**DEPARTMENT OF THE AIR FORCE  
UNITED STATES SPACE FORCE  
SPACE BASE DELTA 1**

Thank you for notifying Schriever Space Force Base (SFB) of the Flying Horse East (FHE) Phase 1 Sketch Plan project (File Number SKP242). We appreciate the opportunity to review this proposed development application and offer the following comments related to specific project documents.

EXISTING DRAINAGE MAP

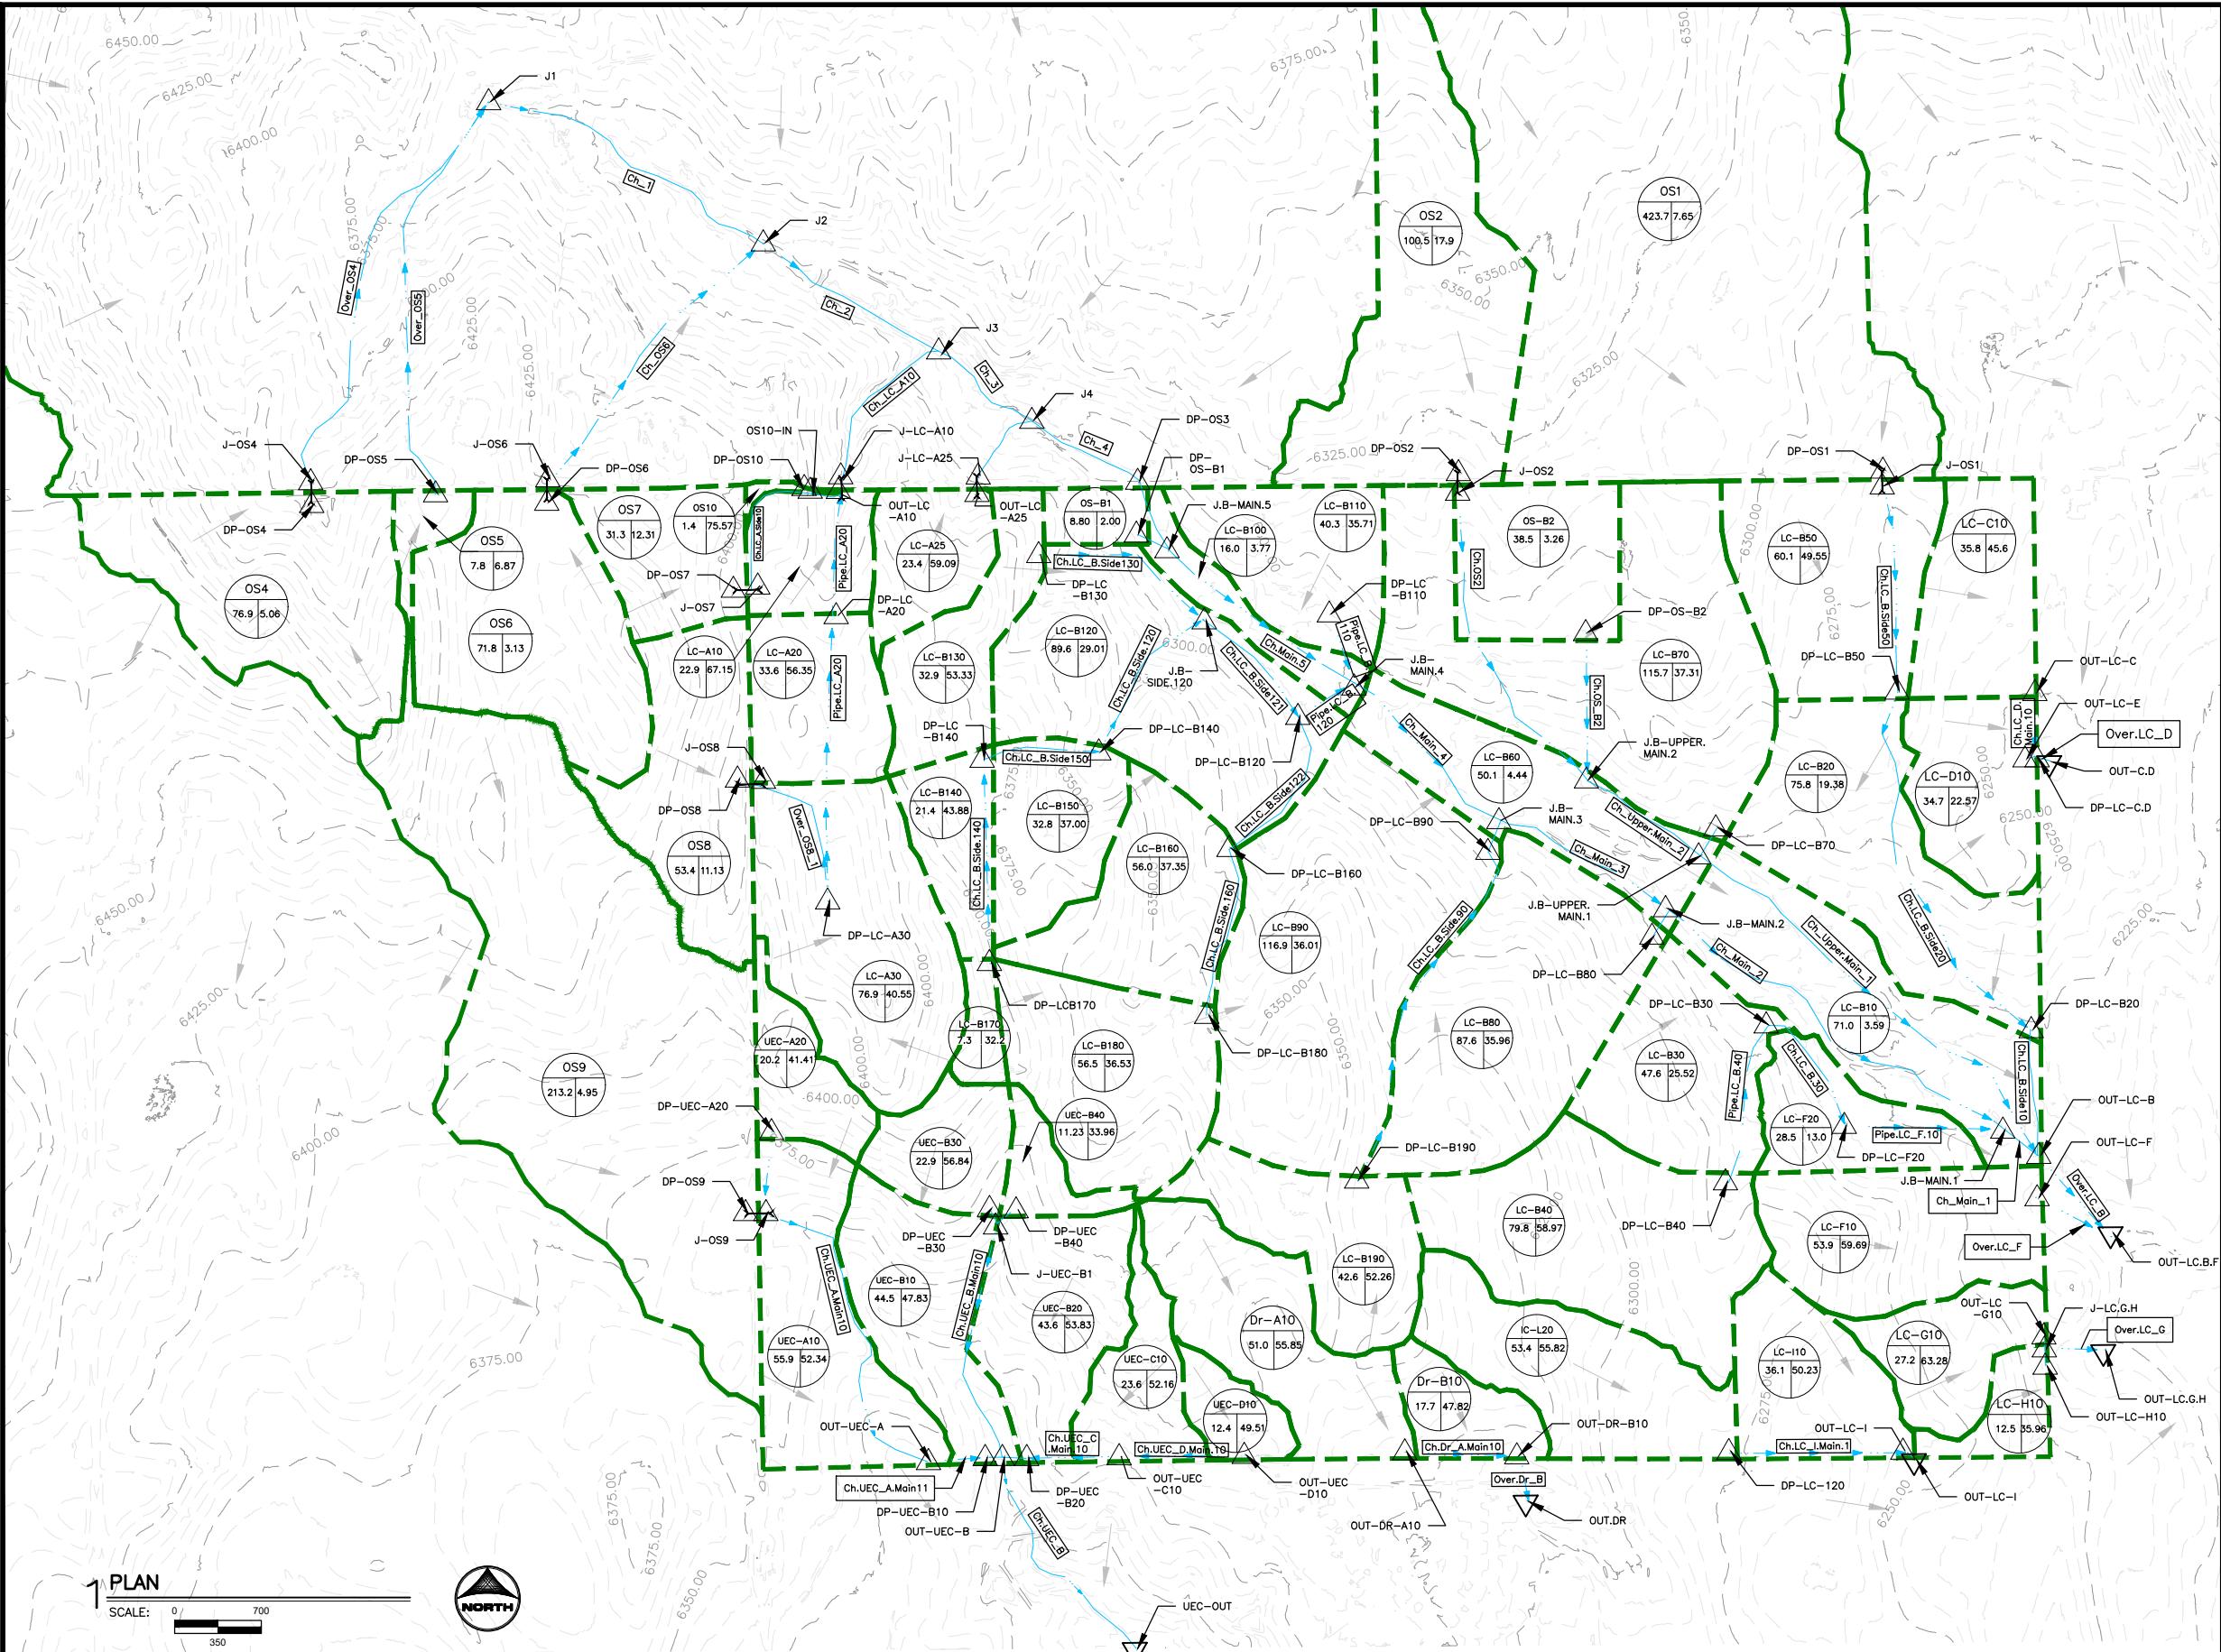
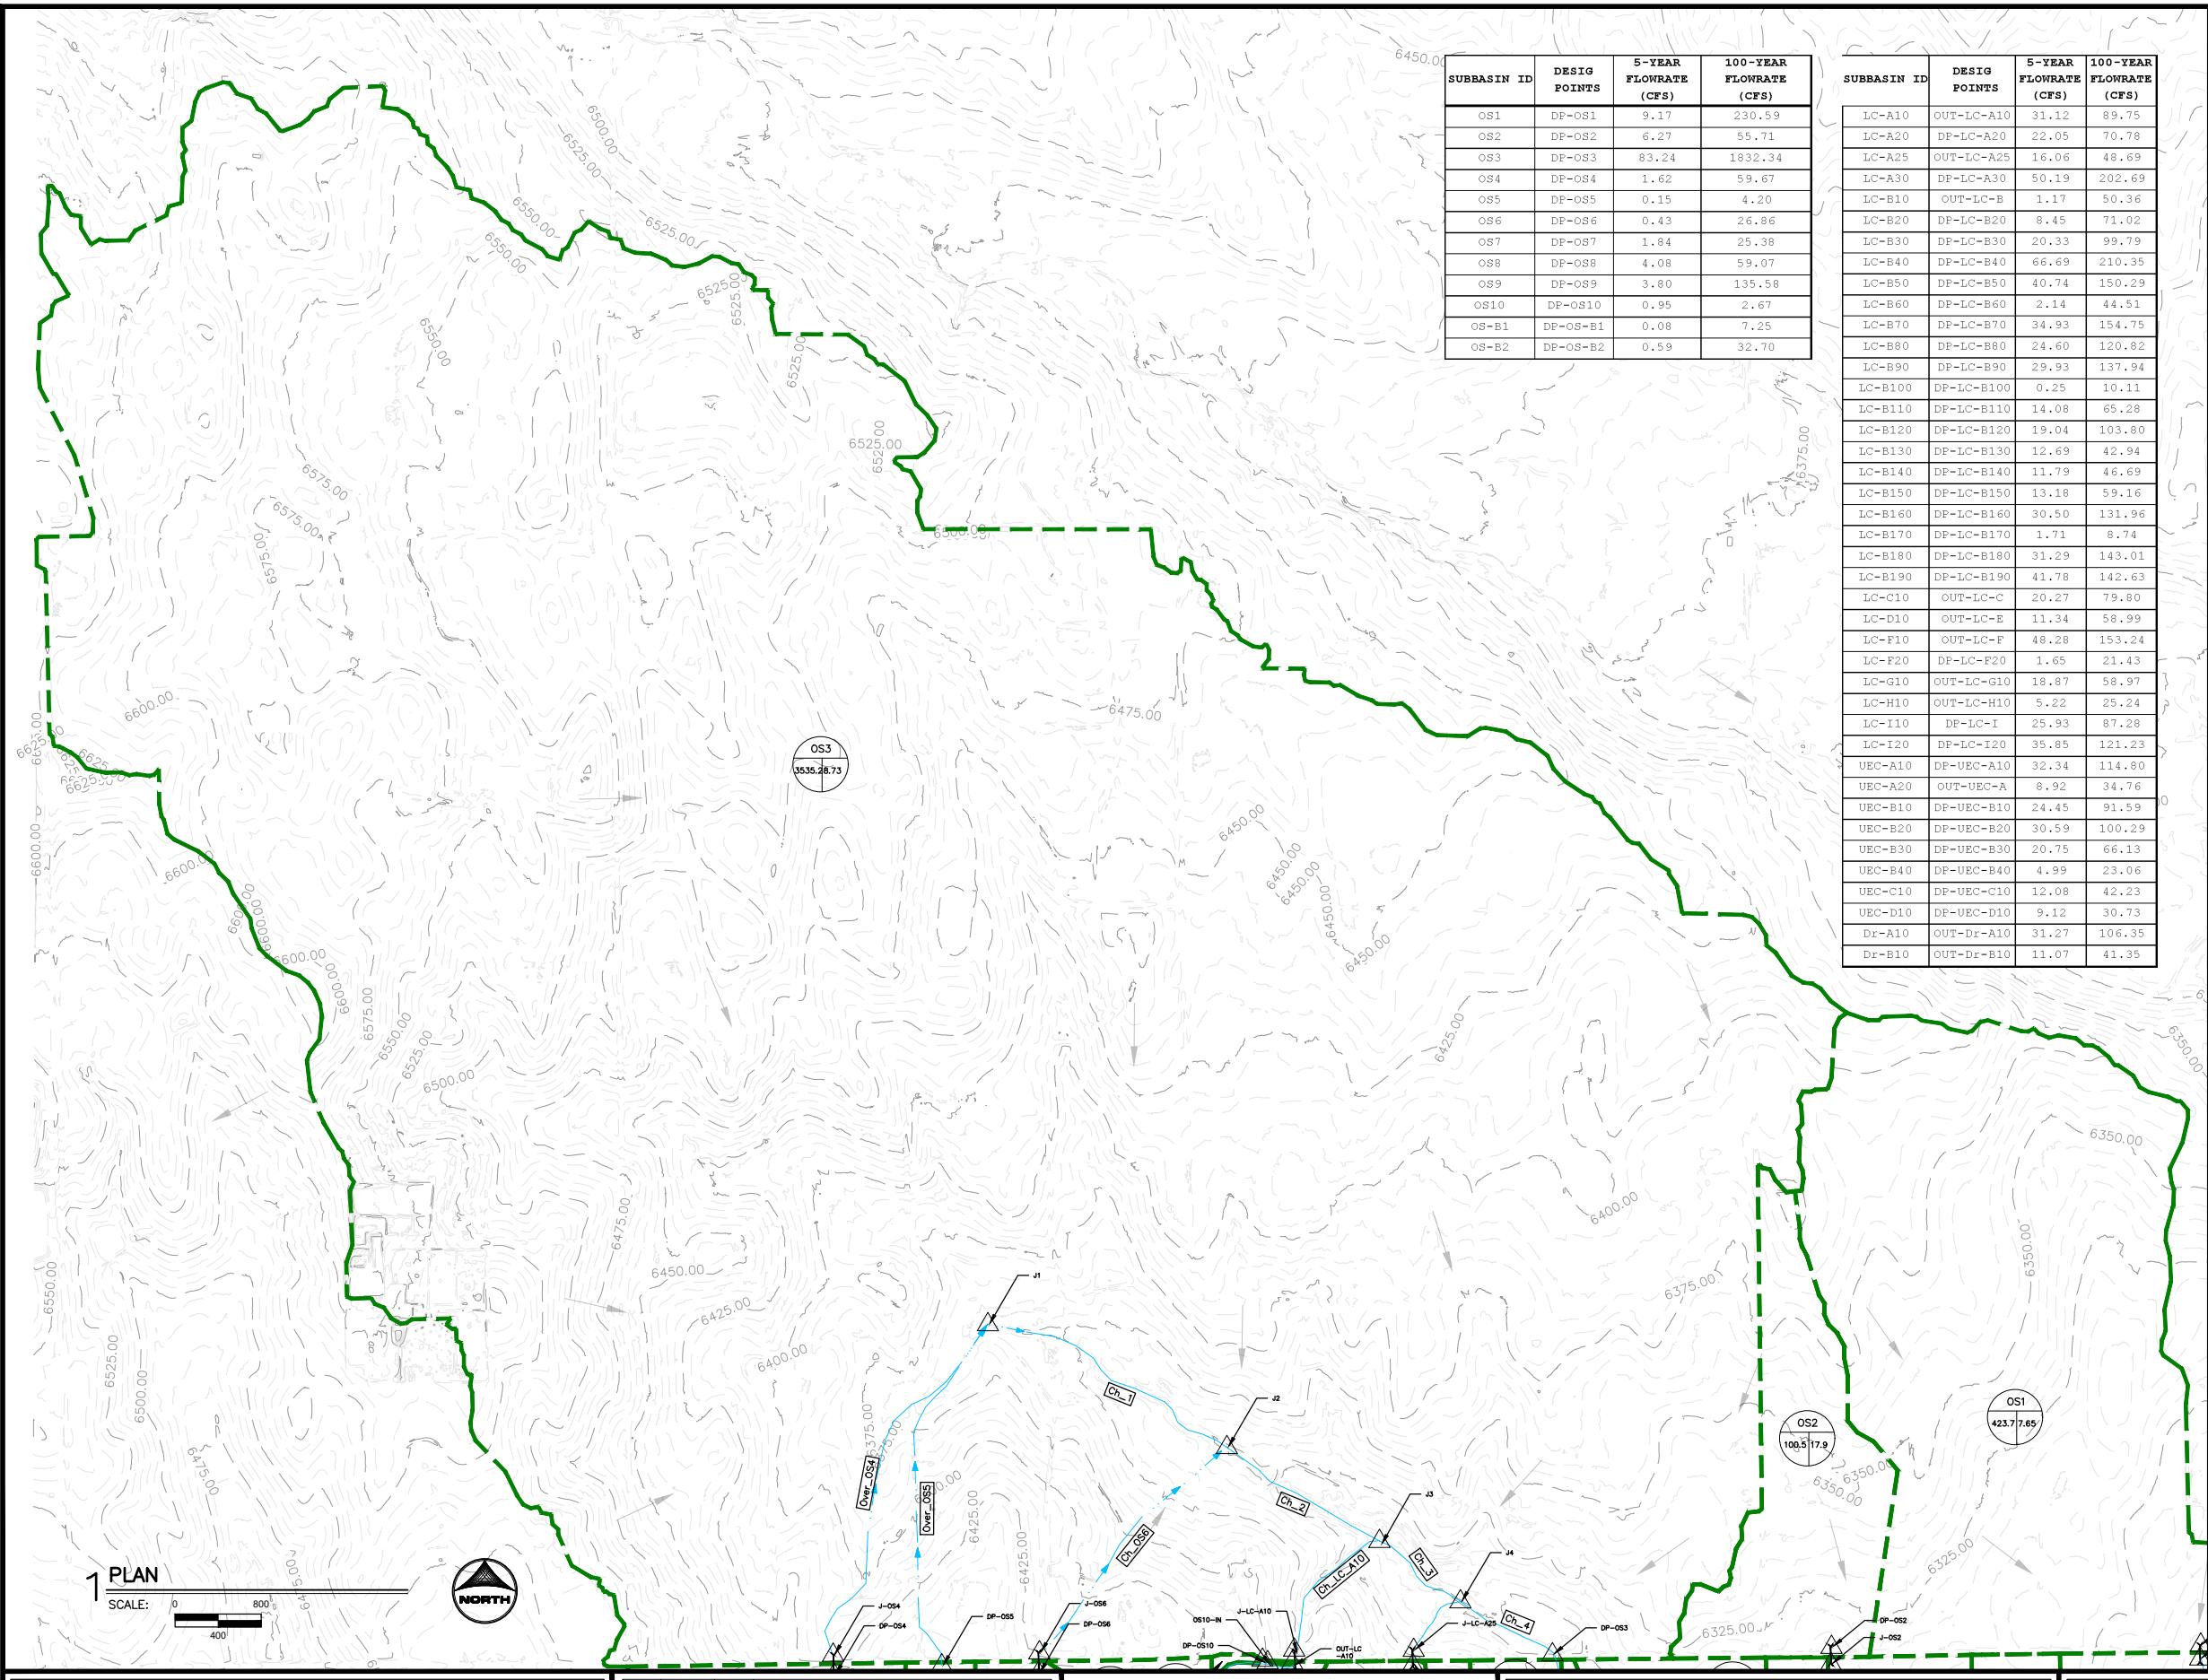
Master Development Drainage Plan: We understand that the intent is for flows from the proposed FHE site will be limited to historic flows. In addition, the cumulative volume of runoff will increase and therefore downstream facilities may see an increase in the duration of flows. An increased flow volume may expedite potential erosion or channel movement. Two small drainage tributaries flow from the FHE site through Schriever SFB. A large-scale Business Park (65% impervious) placed adjacent to Schriever SFB's northern boundary could increase the duration of flows onto the installation and potentially cause flooding and erosion.
